Planning Application Reference No.: 3/2026/0359

Address of Development: Bolton Fold Farm, Alston Lane, longridge pr33bn

Planning Application new agricultural building for cow cubicle at Bolton Fold Farm

Job/Scheme Number	Drawing Number
0795/93	Drawing No 03

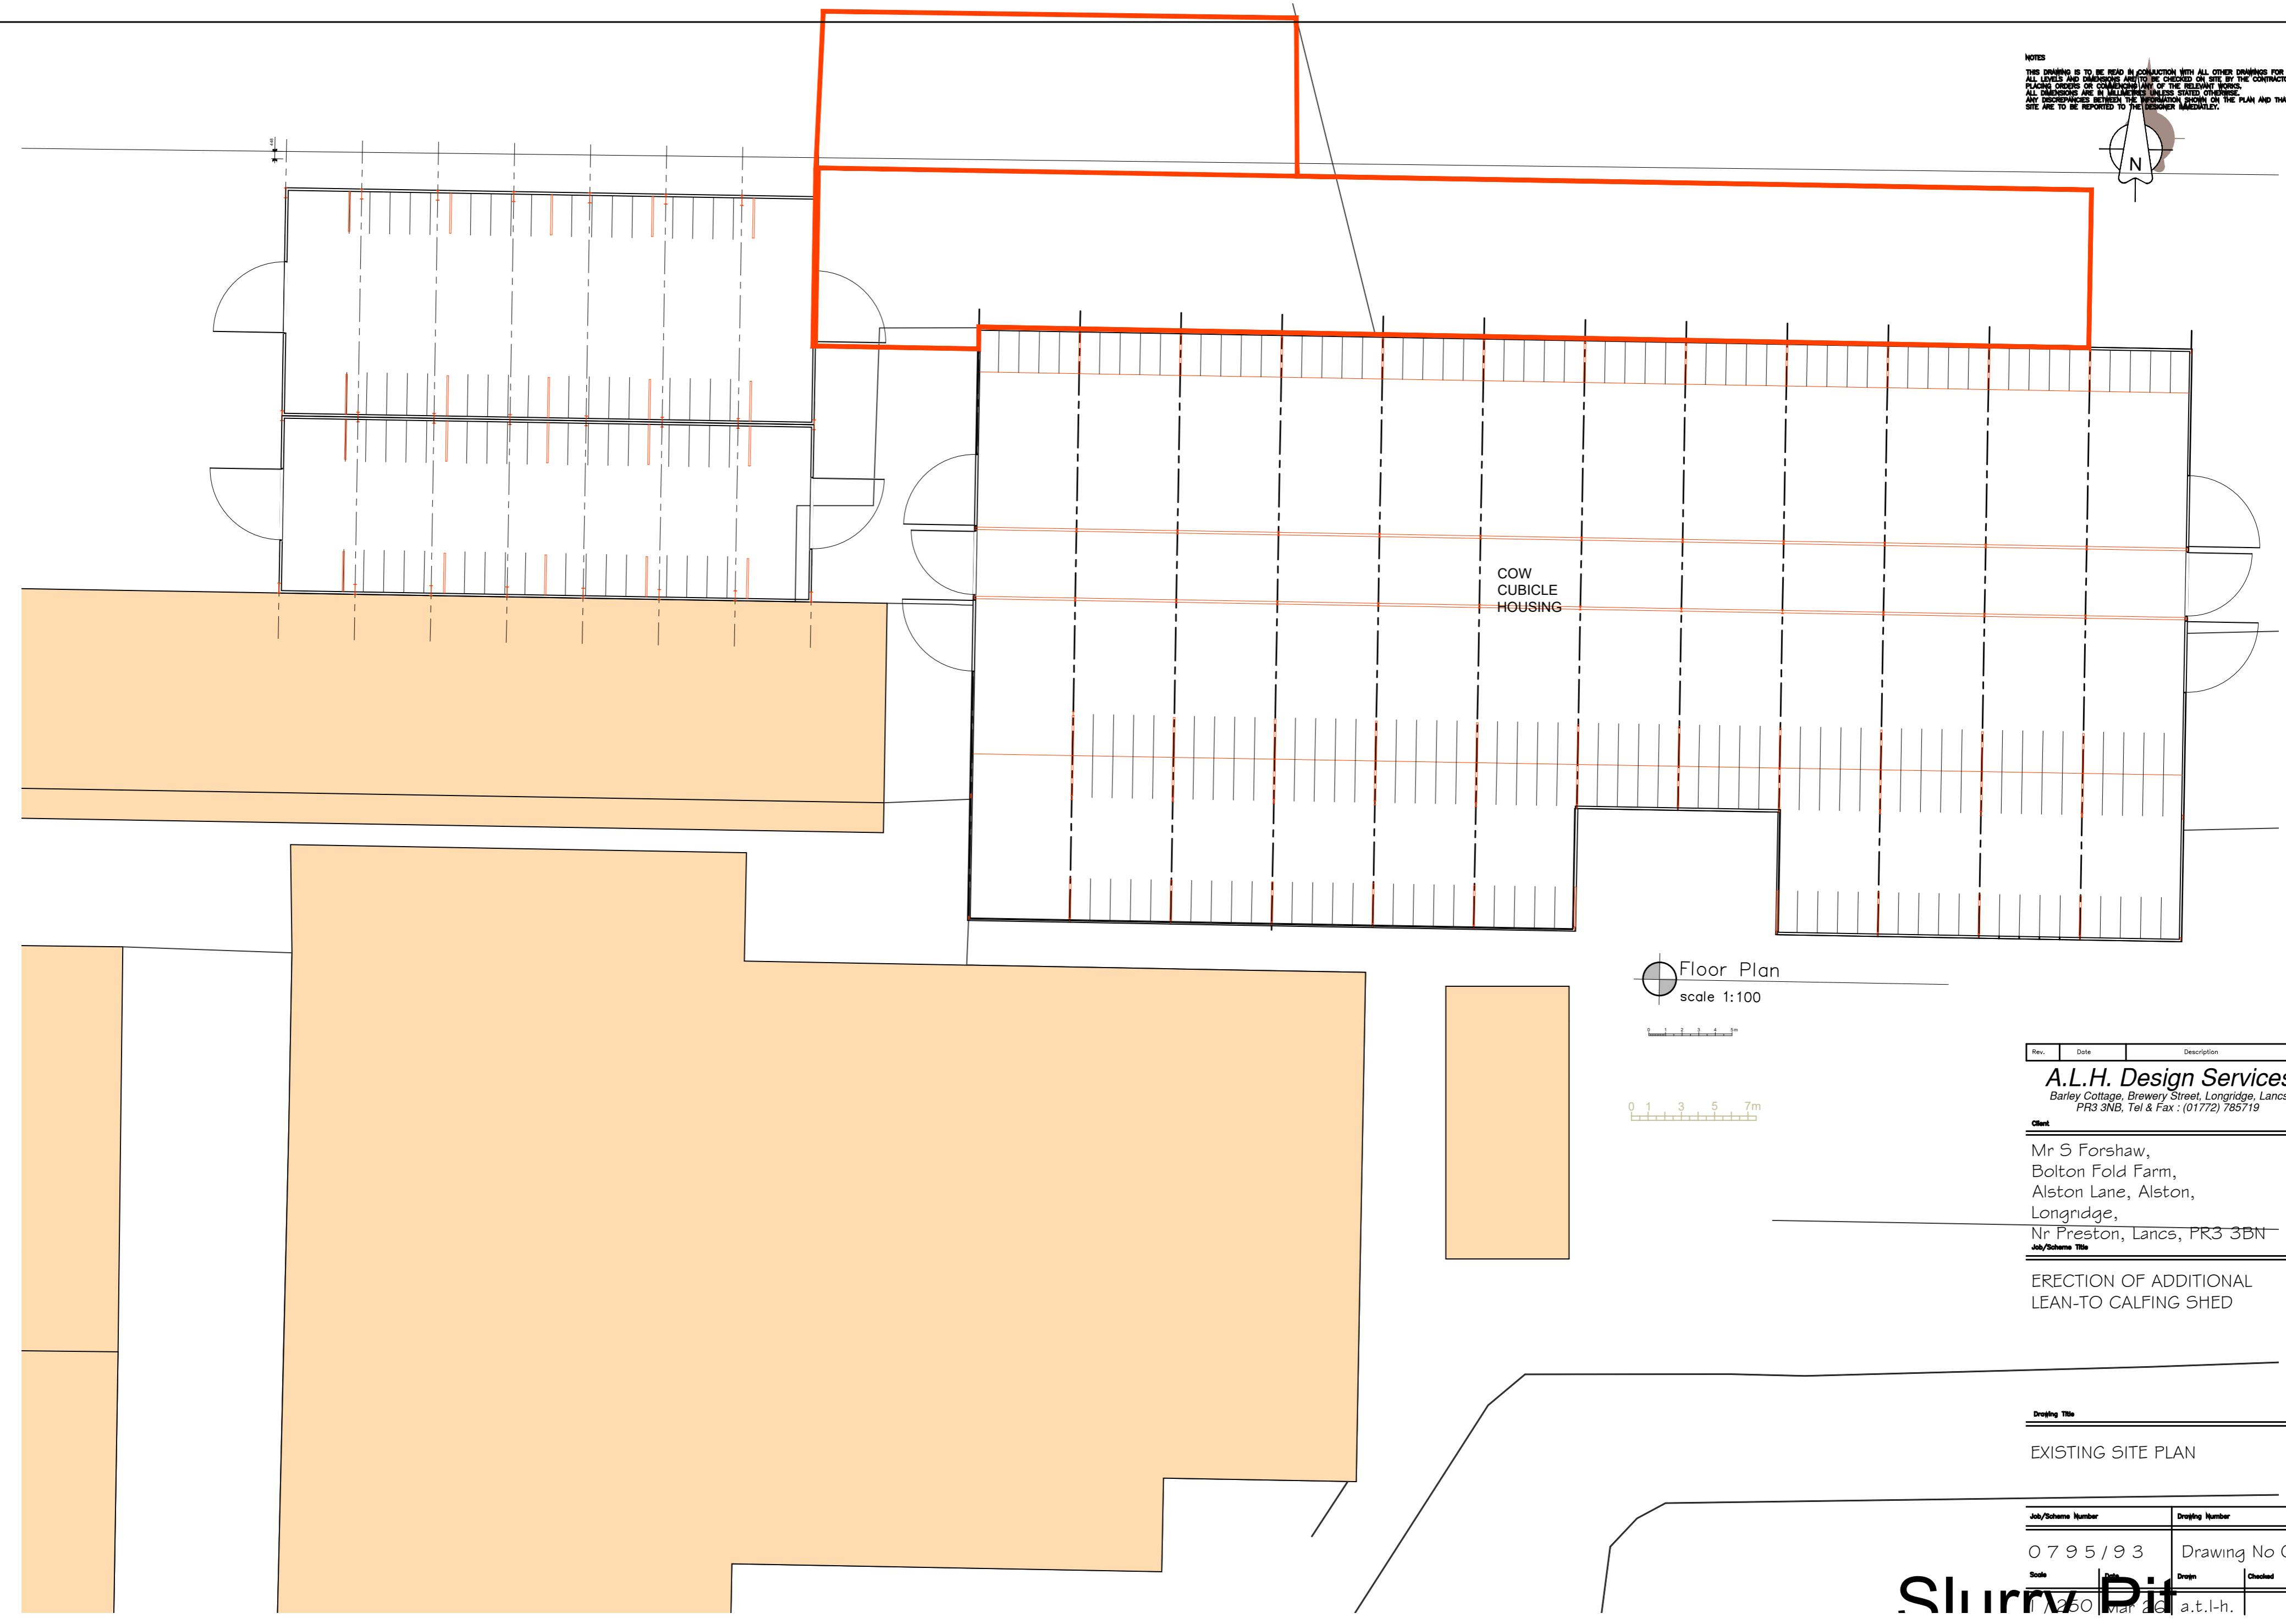
The applicant proposes to erect cow cubicles to house livestock. However, the farm's existing slurry infrastructure is already at or exceeding operational capacity. Under the Storing Silage, Slurry and Agricultural Fuel Oil (SSAFO) Regulations and the Farming Rules for Water, holdings must maintain a minimum of 4 to 6 months of compliant slurry storage to safely navigate winter closed periods when spreading is prohibited.

Introducing additional housed livestock will exponentially increase daily slurry volumes.

Job/Scheme Number	Drawing Number		
0795/93	Drawing No 09		
Scale	Date	Drawn	Checked
1 / 250	Mar 26	a.t.l-h.

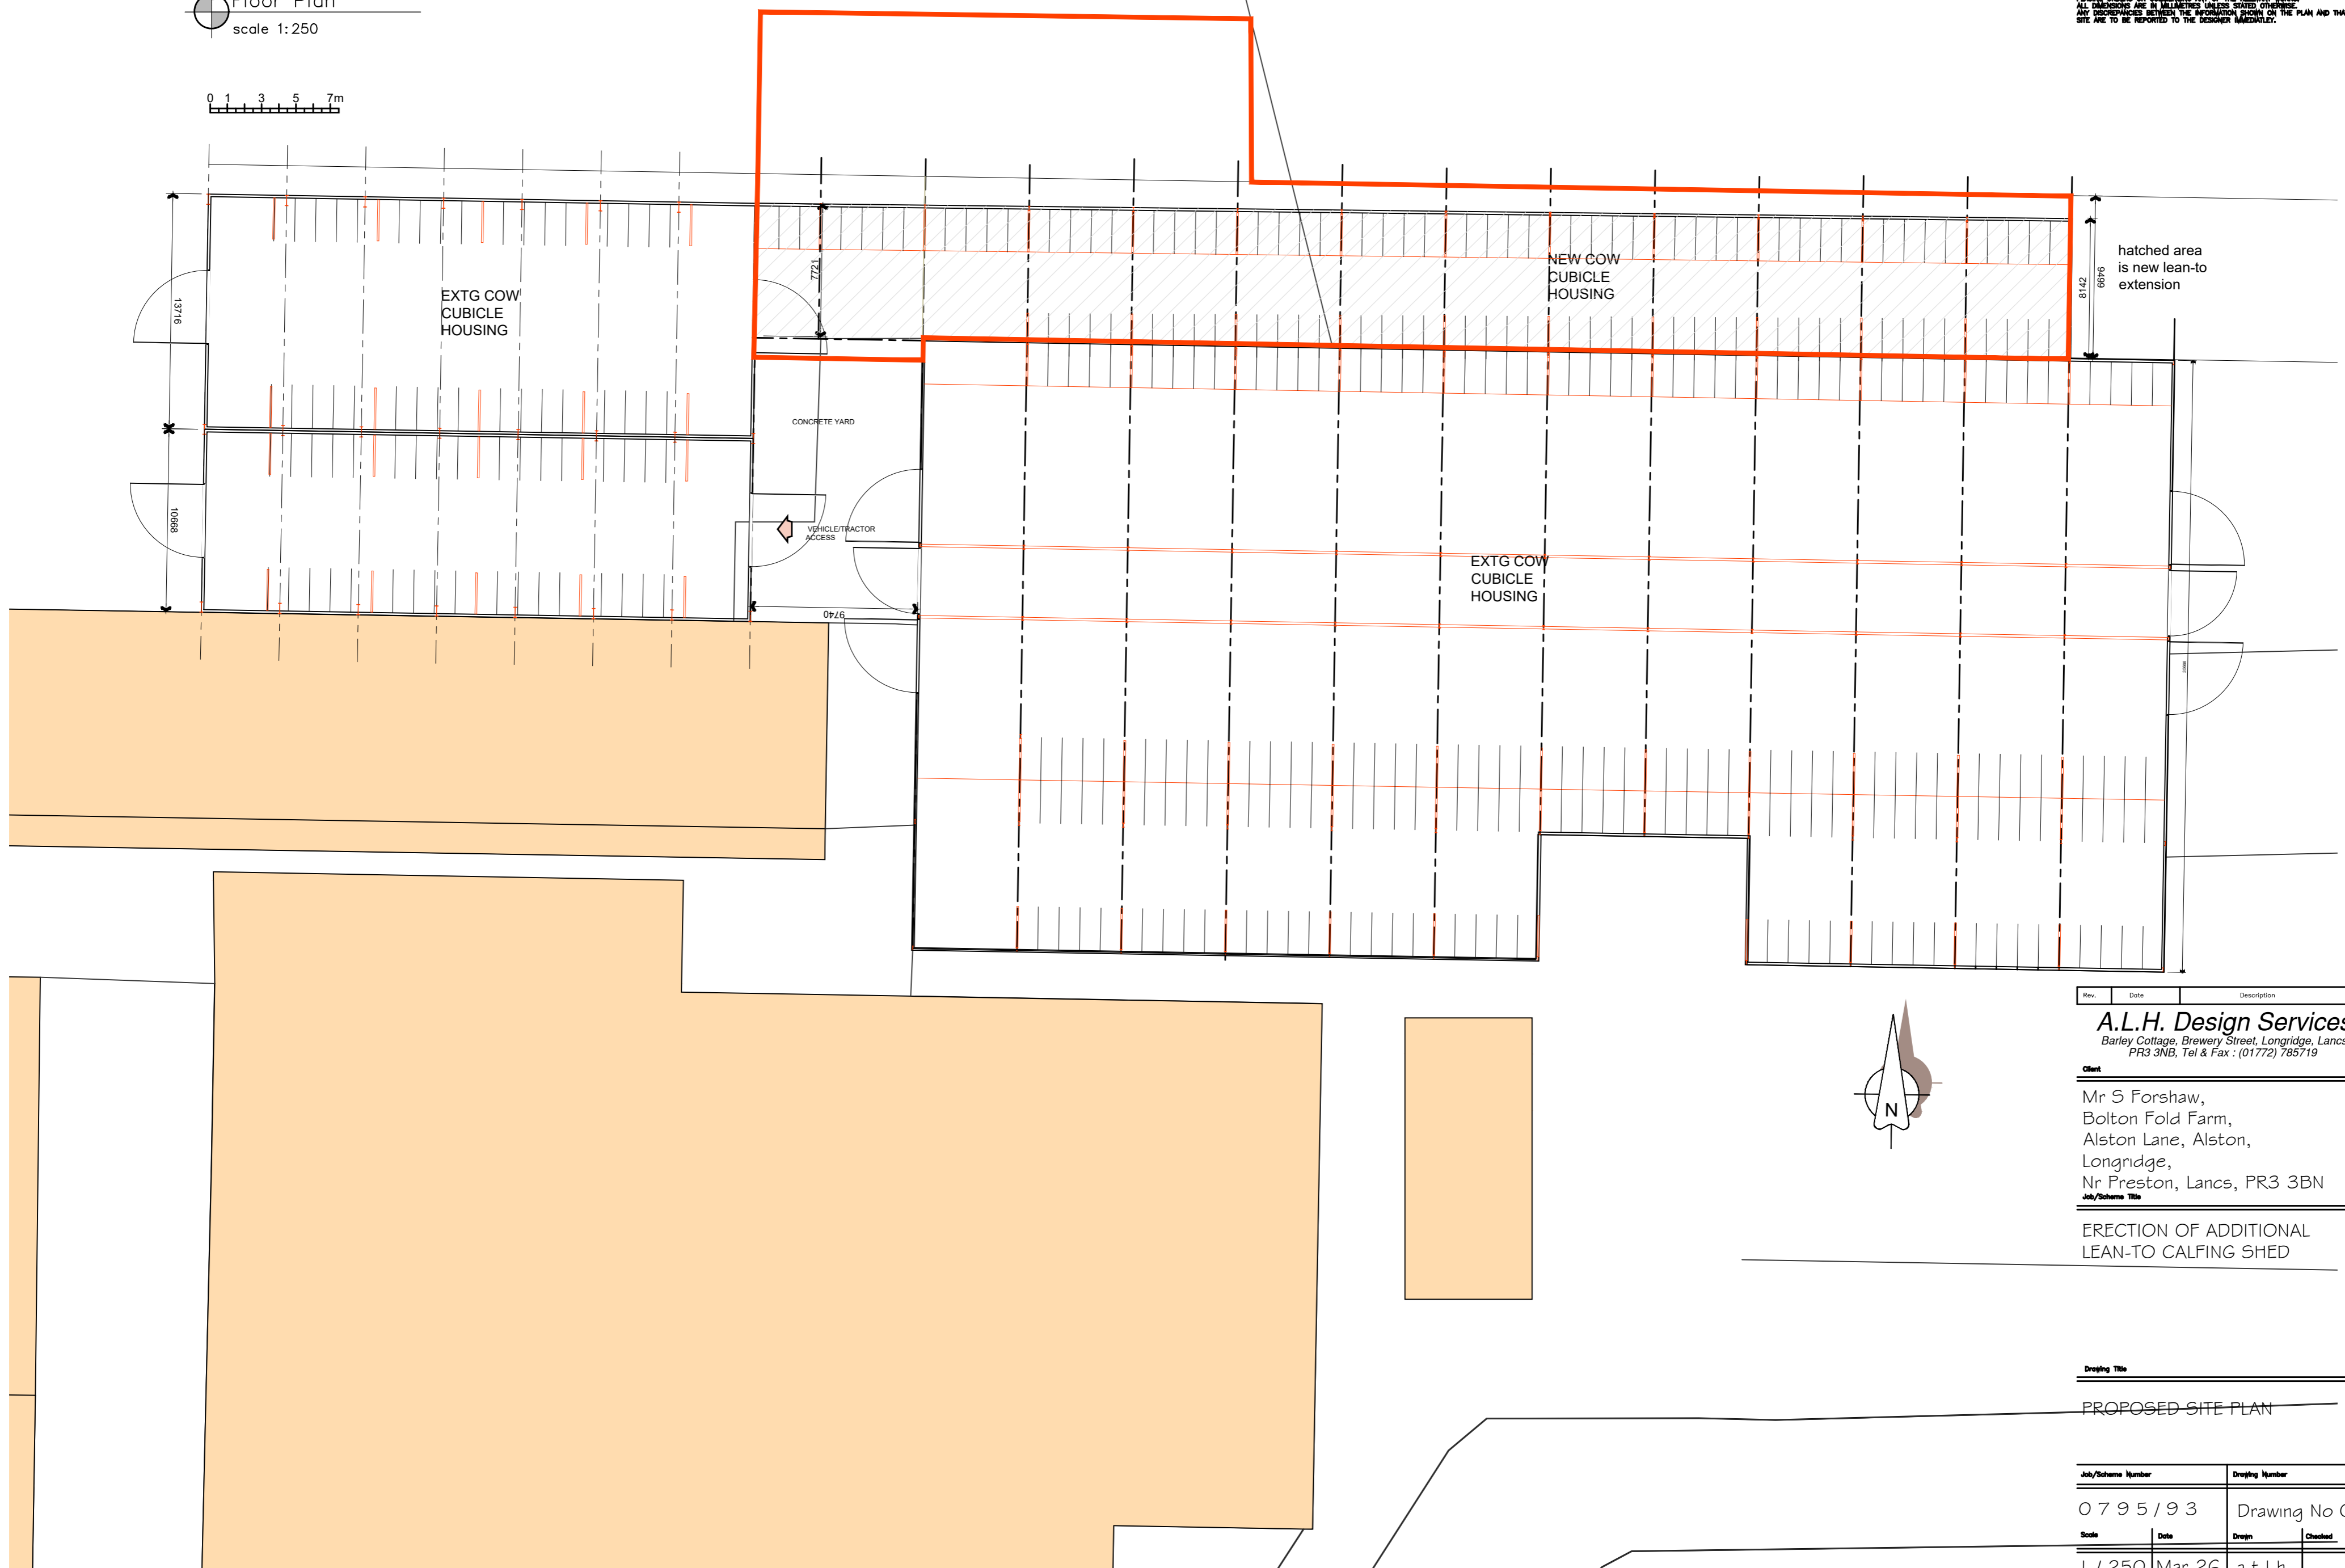
The application fails to provide a comprehensive Slurry Management Plan or detail the construction of new, legally compliant, covered storage tanks.

The application plans do not demonstrate a clear separation of "clean" rainwater (from roofs and clean yards) and "dirty" water (from livestock scraping passages and handling areas). By letting rainwater mix with yard runoff, the volume of material classified as "slurry" will skyrocket, placing even greater pressure on a storage system that is already failing.
